From: Simon Davis
Sent: 08 August 2017 15:31
To: Matthew Driver [REDACTED]
Subject: BN/28/17/RES - The Lillies, Barnham Road

I have been looking over the reserved matters submission and comparing it to the advice I gave at the pre-application stage. I have the following initial queries based on this comparison:

JOB NO.	DRAWING NO.	REV
MATT151202	SL.01	P5

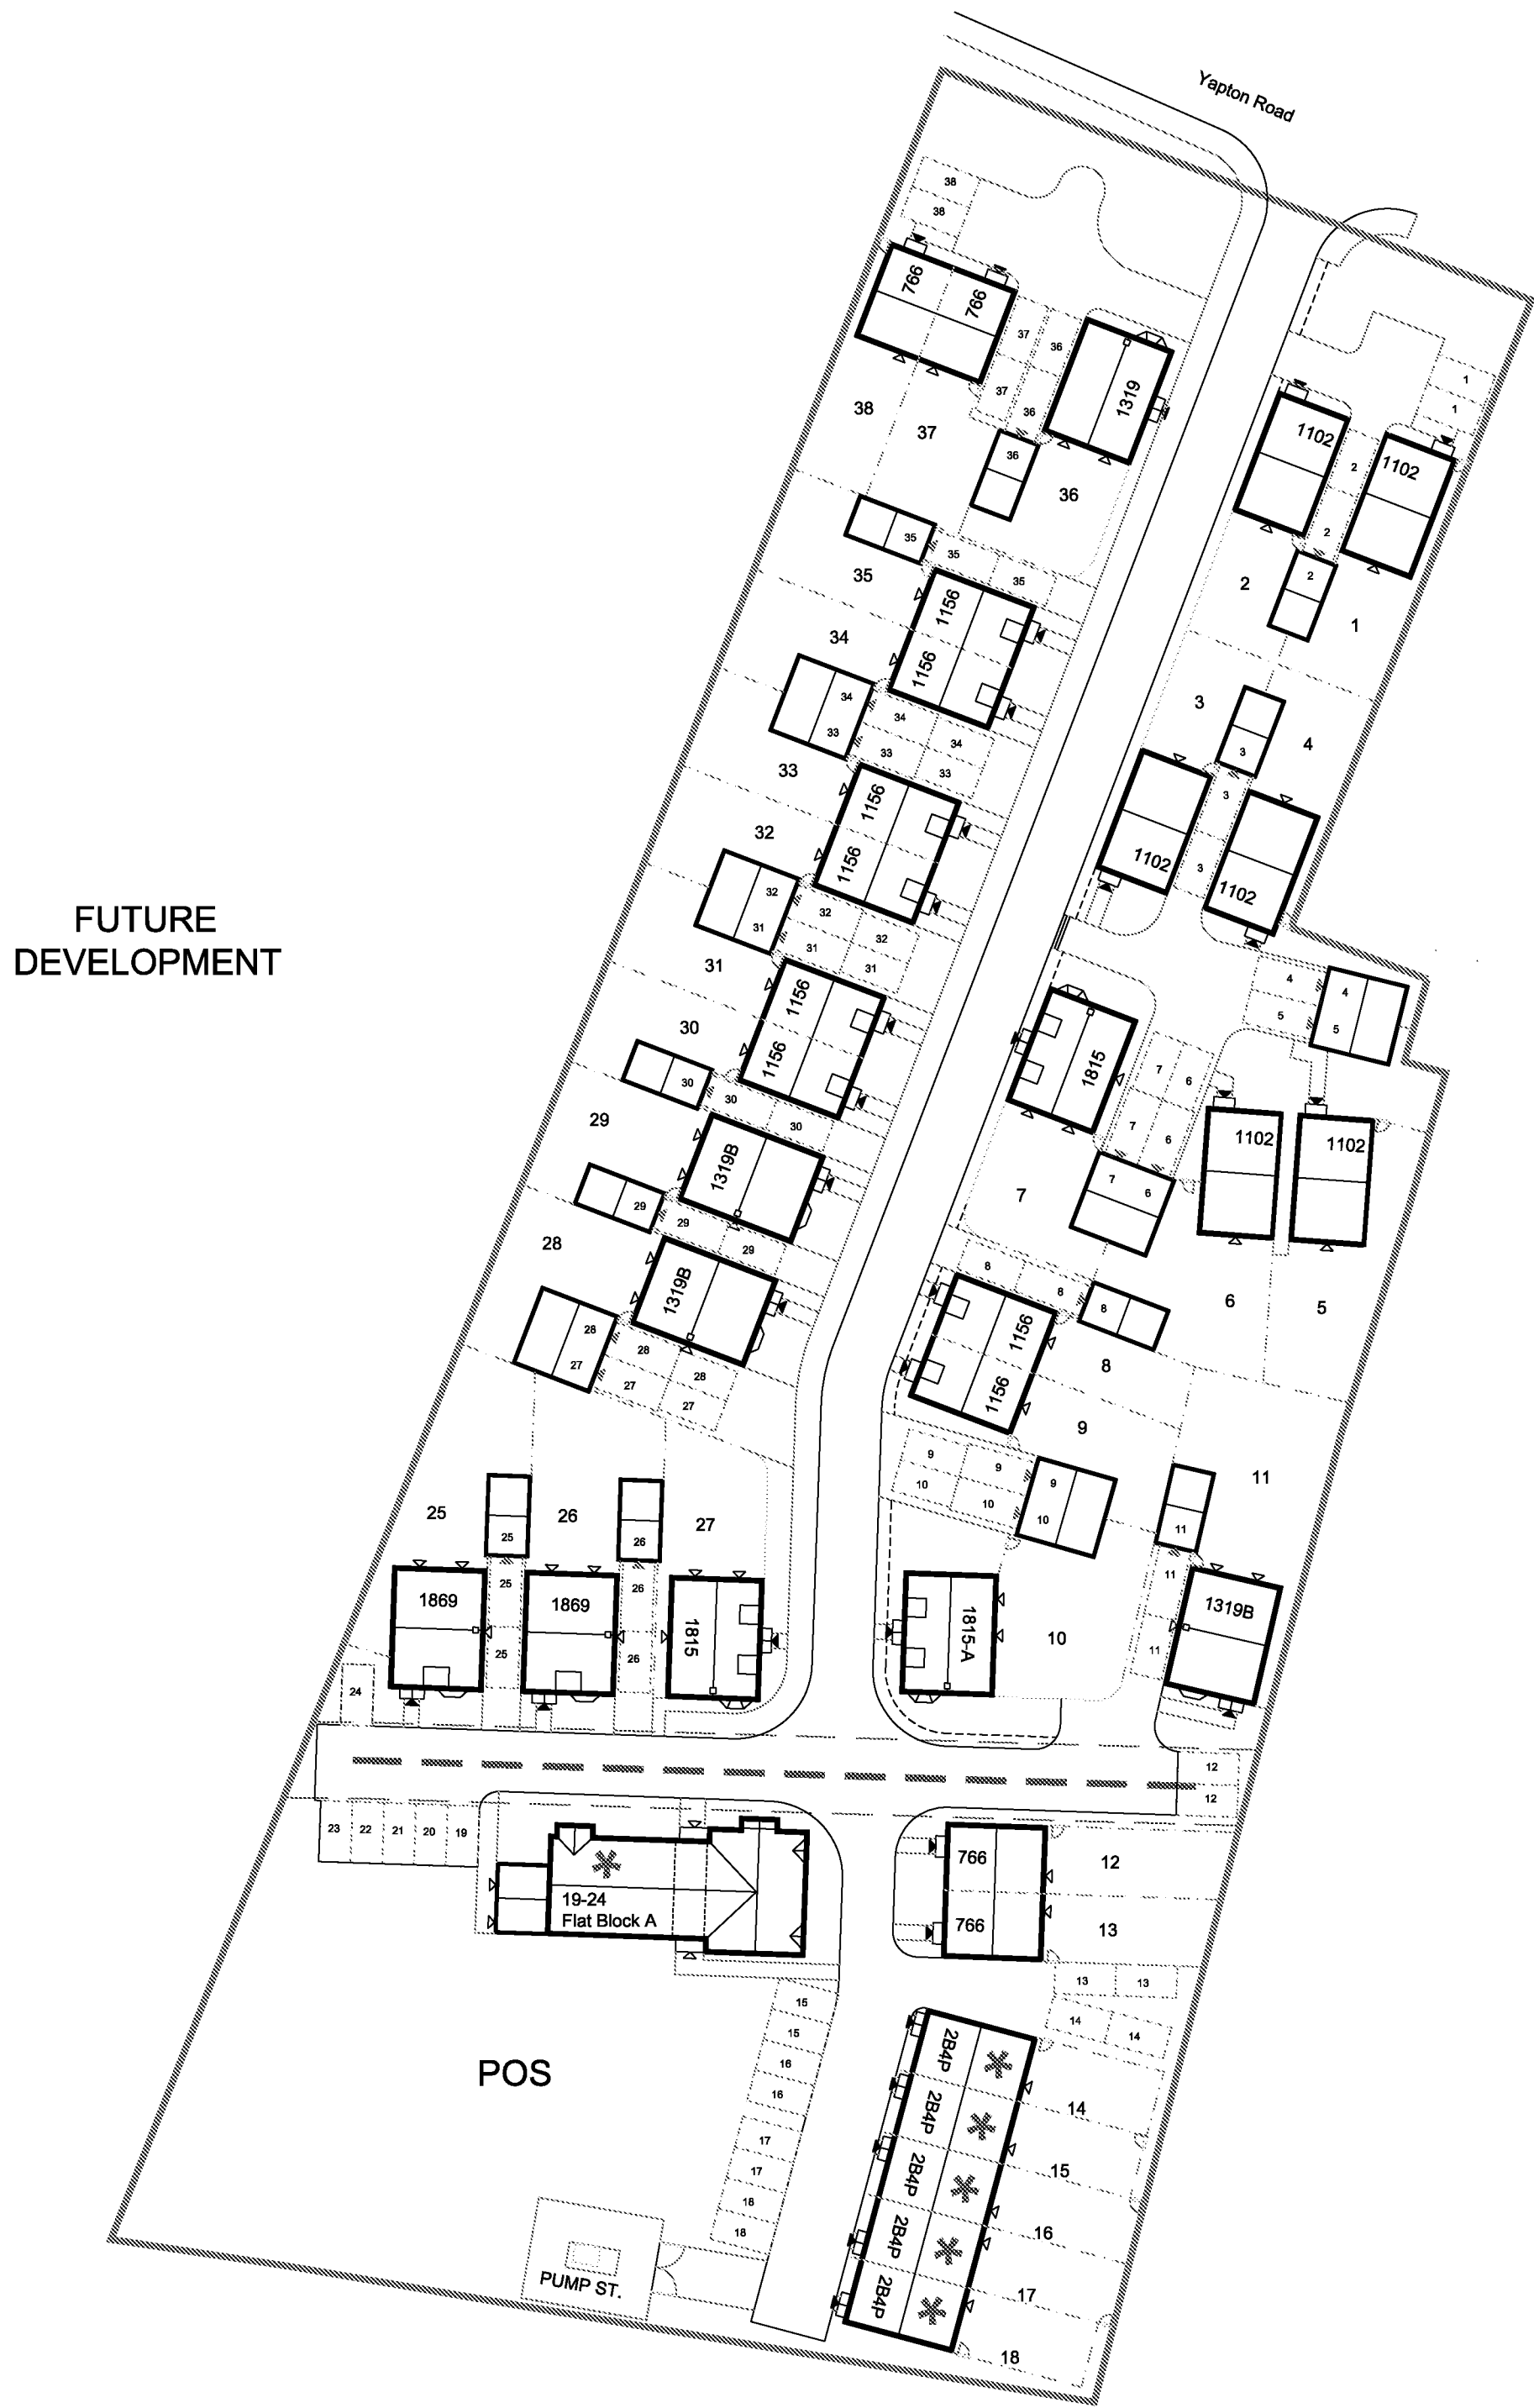
- I recommended that there be a link between this site and that next door (as approved by BN/43/16/PL). It would appear as though there is no boundary shown on the western side of the proposed POS which would indicate the potential to move between the two sites. Can you confirm this to be the case.

- I recommended that the flatted building be shown with some curtilage/defensible space particularly on the rear elevation which backs onto the POS. This has not been shown. The current arrangement would allow users of the POS to get right up to the ground floor windows.

- I requested the submission of a schedule detailing the rear garden area and rear garden depth measurements for each plot. I also requested the submission of a schedule which details the internal space measurements for each dwelling. Neither has been provided. I also note that no private space has been shown for the flats. Could balconies not be incorporated into the southern elevation?
